From: Michael Eastham
Sent: 15 September 2017 17:56
To: Planning.Responses
Subject: FW: WA/44/17/OUT - Land East of Tye Lane, Walberton

I am busy drafting the Committee report for outline planning application (WA/44/17/OUT) – Land East of Tye Lane, Walberton.

ADC ARBORICULTURE:

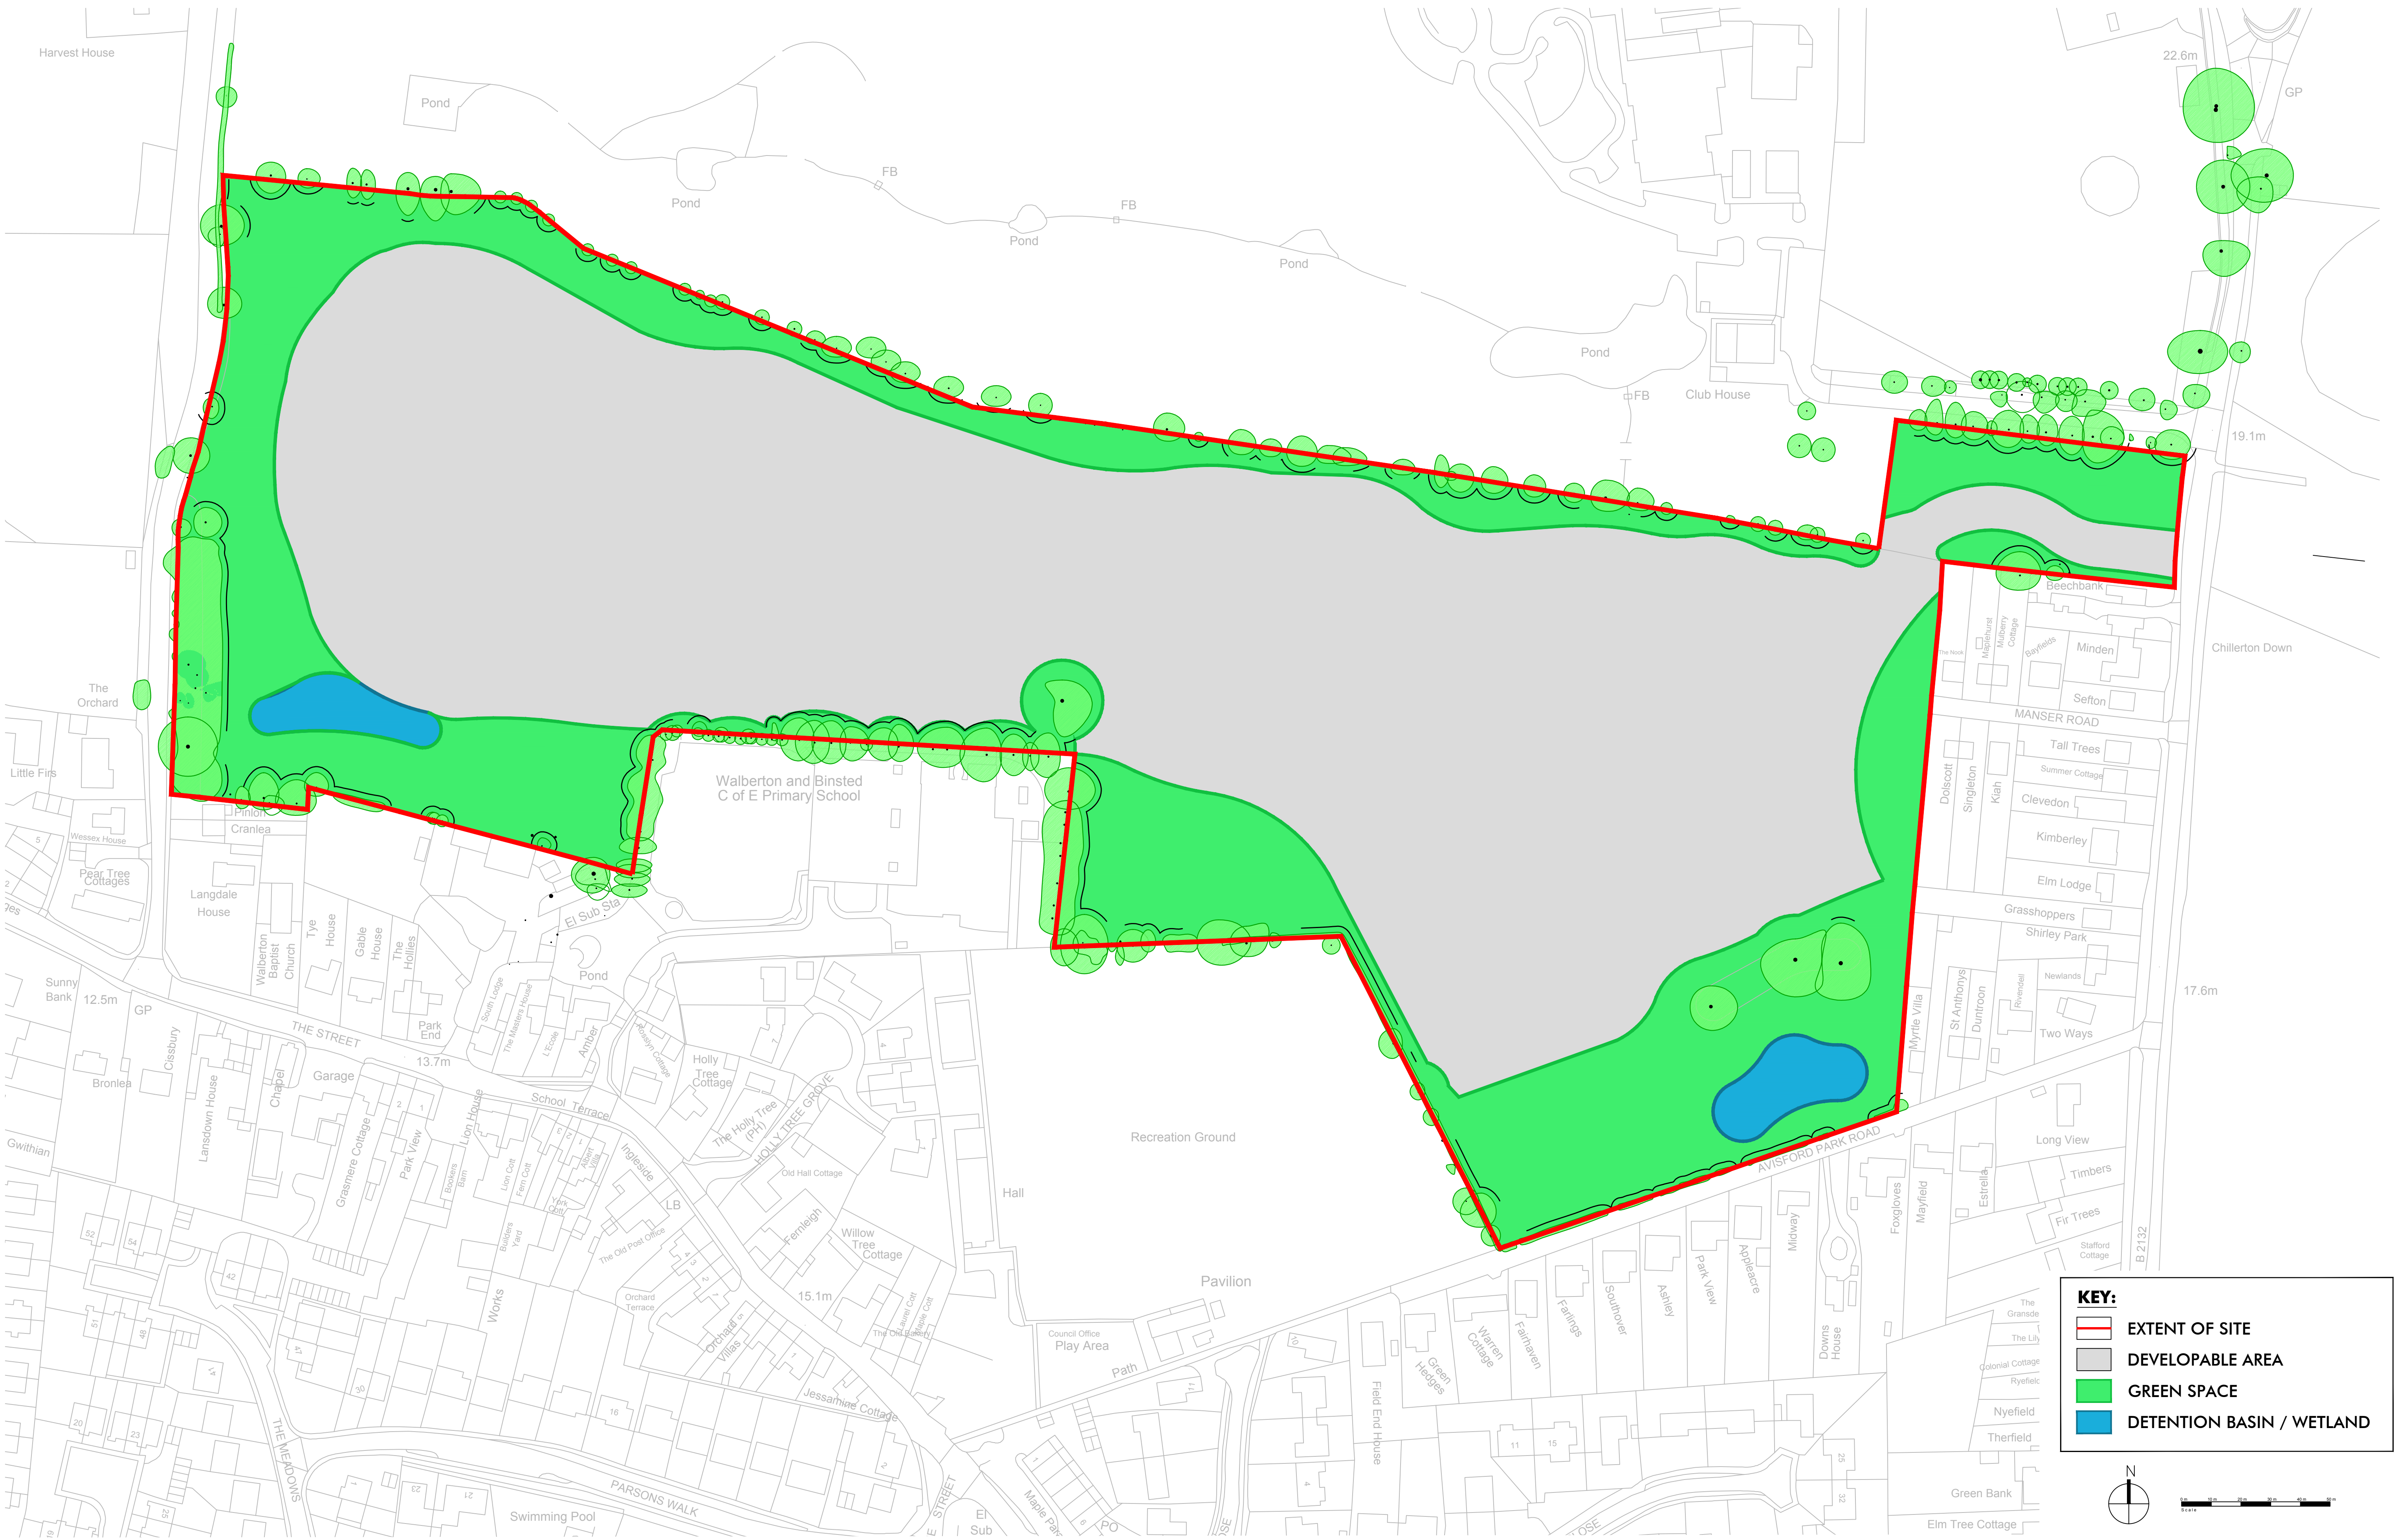
The Council's Arboricultural Officer raised an objection to the illustrative masterplan which identified footpaths, access drives and roads within the Root Protection Areas (RPAs) of trees within the application site. The Arboricultural Officer has requested the submission of amended plans which show the footpaths, access drives and roads moved outside of the Root Protection Areas. The Arboricultural Officer also recommended that a tree preservation order (TPO) is made to protect four trees that make a significant impact in the landscape and should be afforded full protection status. Three of the trees are growing along the western boundary of the site with Tye Lane, and the fourth tree is located immediately north of the boundary of the site with Walberton and Binstead C of E Primary School.

As the illustrative masterplan is indicative, we can ask the applicant to submit details of the routes of the footpaths, access drives and roads moved away from the Root Protection Areas (RPAs) at the Reserved Matters stage; thereby overcoming your objection.
